CITY OF ALBUQUERQUE

Re: First Nations Community Health Source (FNCH)
505 Madeira Dr. SE, 87108
Request for Certificate of Occupancy
Transportation Development Final Inspection
Engineer's/Architect's Stamp dated 8-17-20 (L18D085)
Certification dated 9-14-21

ASI-003

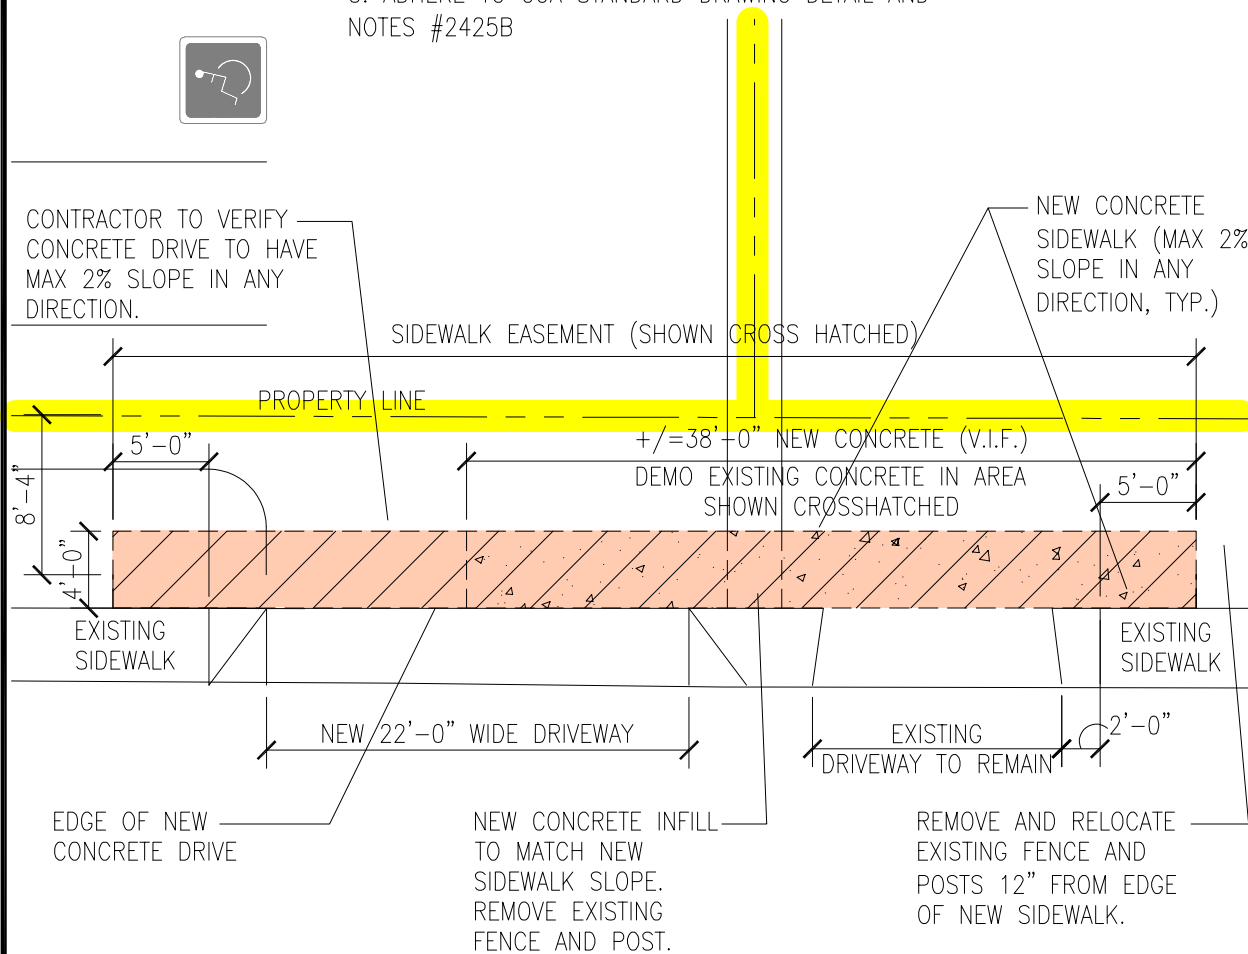
- Driveway is not ADA compliant. Key note #7. Follow City Standard Drawing 2425. See attached photos & design standards.
- Please add Bick Rack & Motorcycle signs.
